Please ask for: Mrs D Johnson
Email: daun.johnson@arun.gov.uk
Telephone: 01903 737762
Our Ref: BN/8/22/PL
Your Ref:
Date: 31st January 2022

Application for Planning Permission

Development: Retention of existing site entrance (resubmission following BN/97/21/PL. This site is in CIL Zone 3 (Zero Rated) as other development.
Location: Land To South And West (Rear) Of Birchwood House Church Lane Barnham PO22 0DB

I regret that I am unable to accept your documents as a valid application until the following item(s) have been received or resolved :-

Location Plan
Scale 1:1250

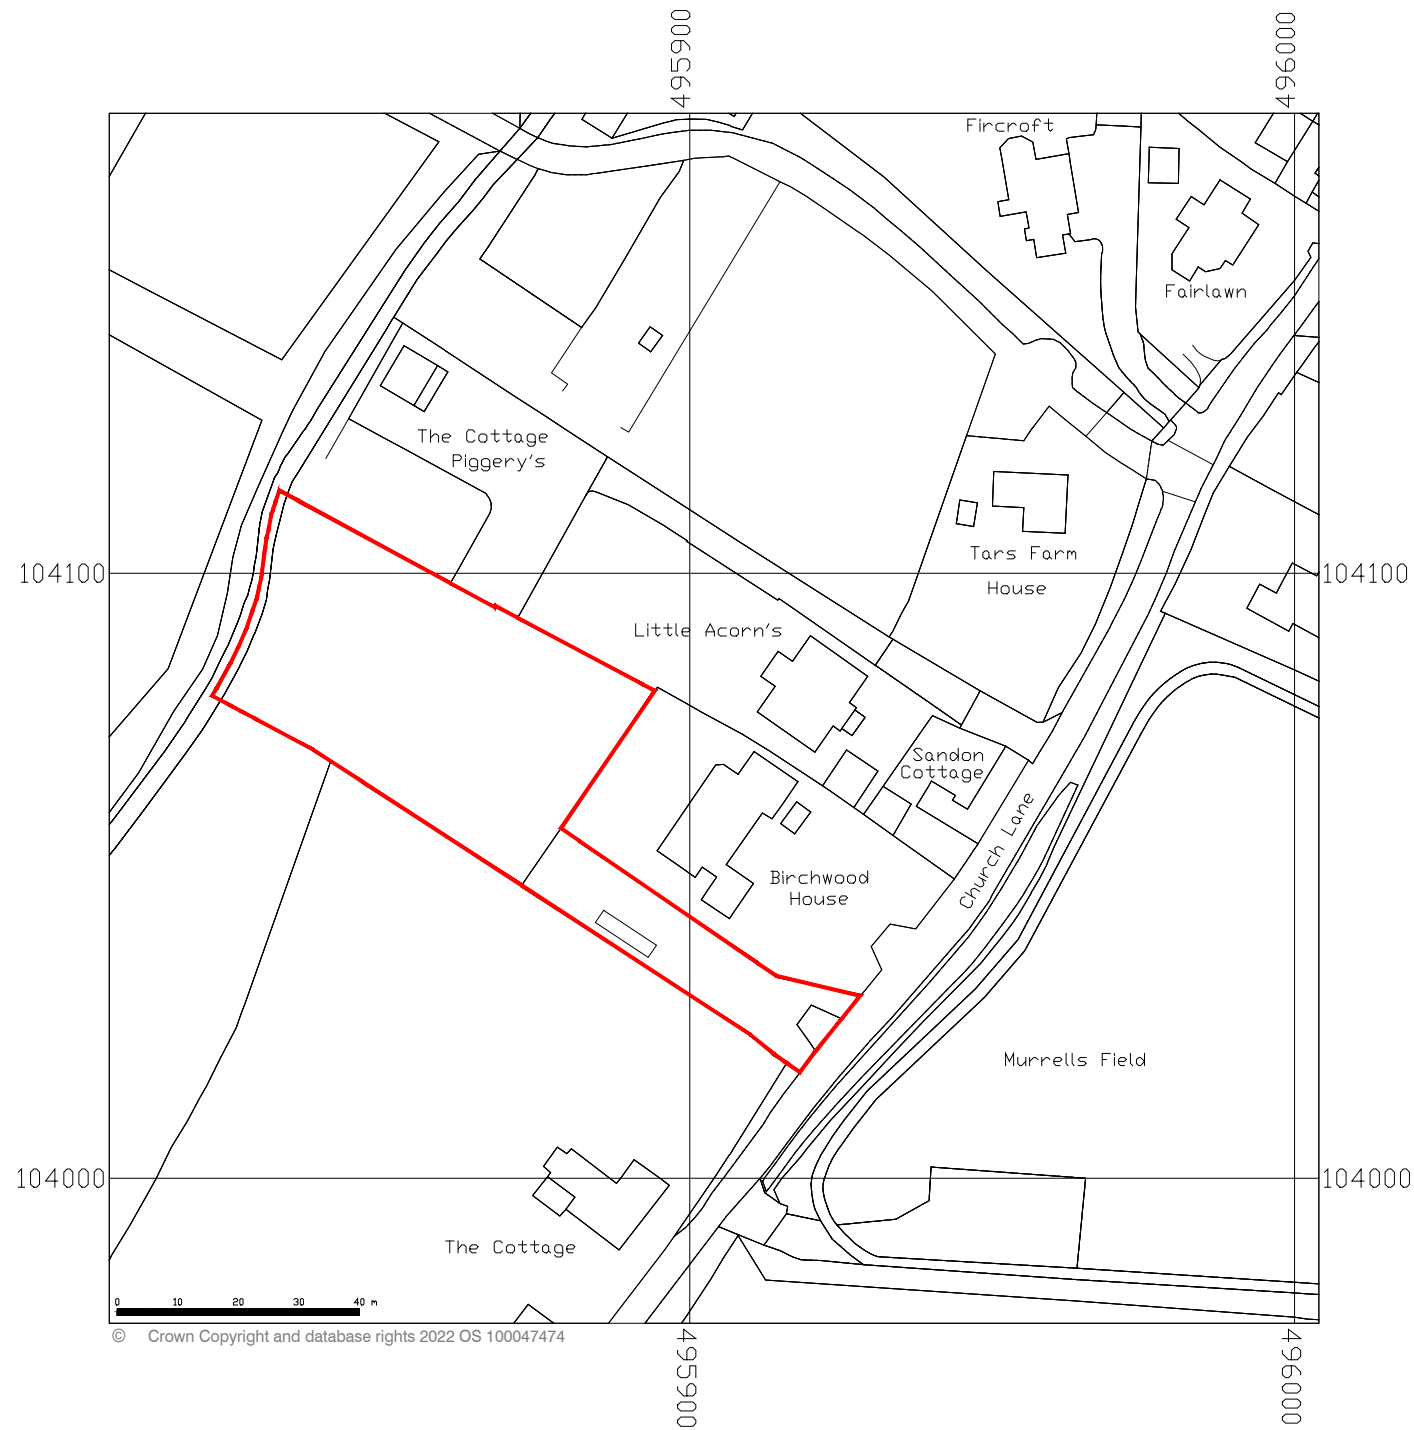
Location Plan

Please provide a blue edge around any land in control/owned by applicant.

Site Block Plan
Scale 1:500

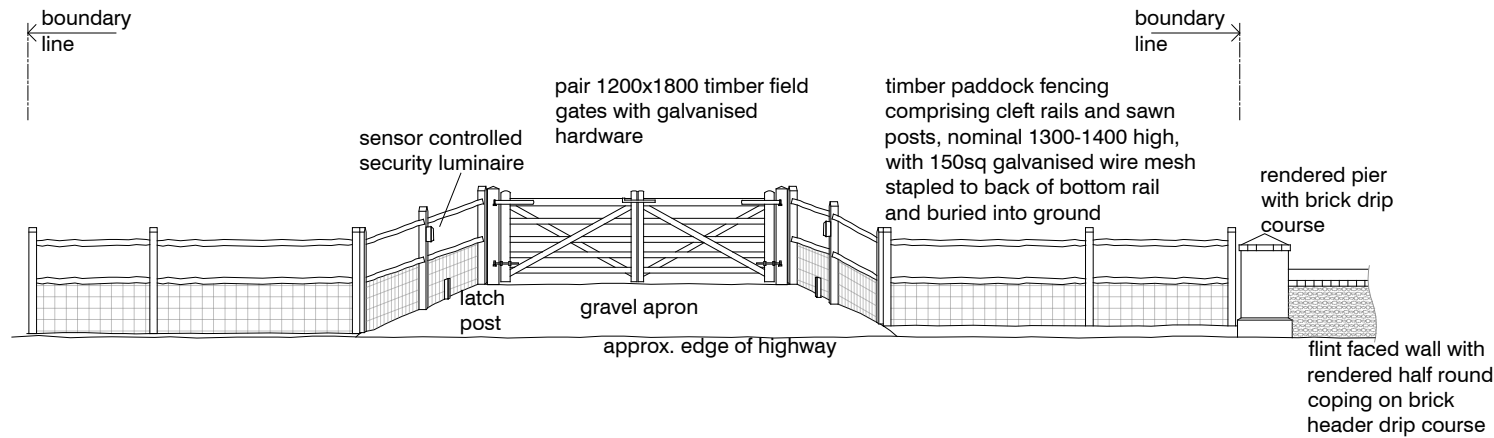
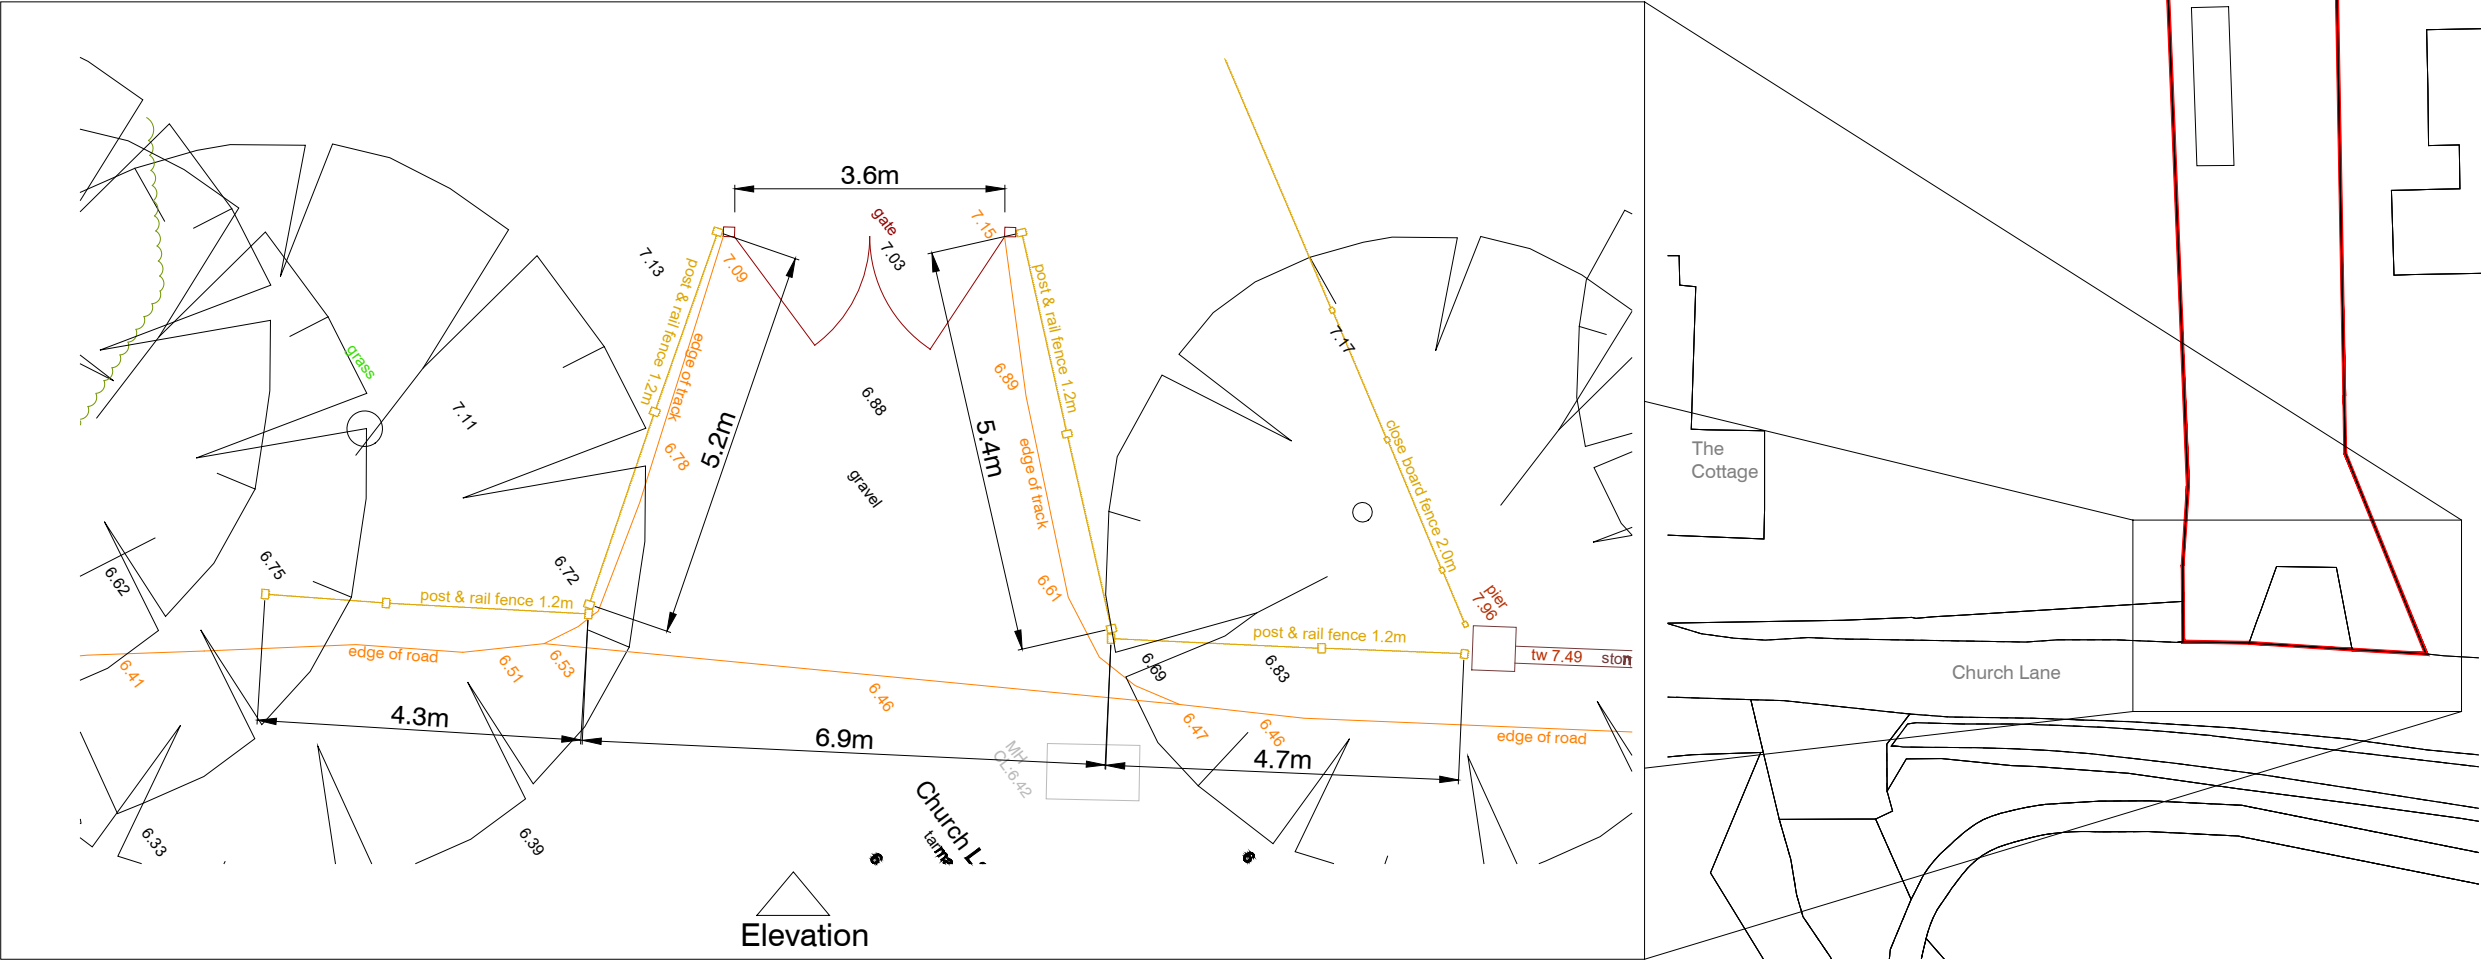
Block Plan

Please submit an electronic block plan in pdf format at a scale of 1:500. Further details of what must be included on the plan can be found in the Validation Requirements List.
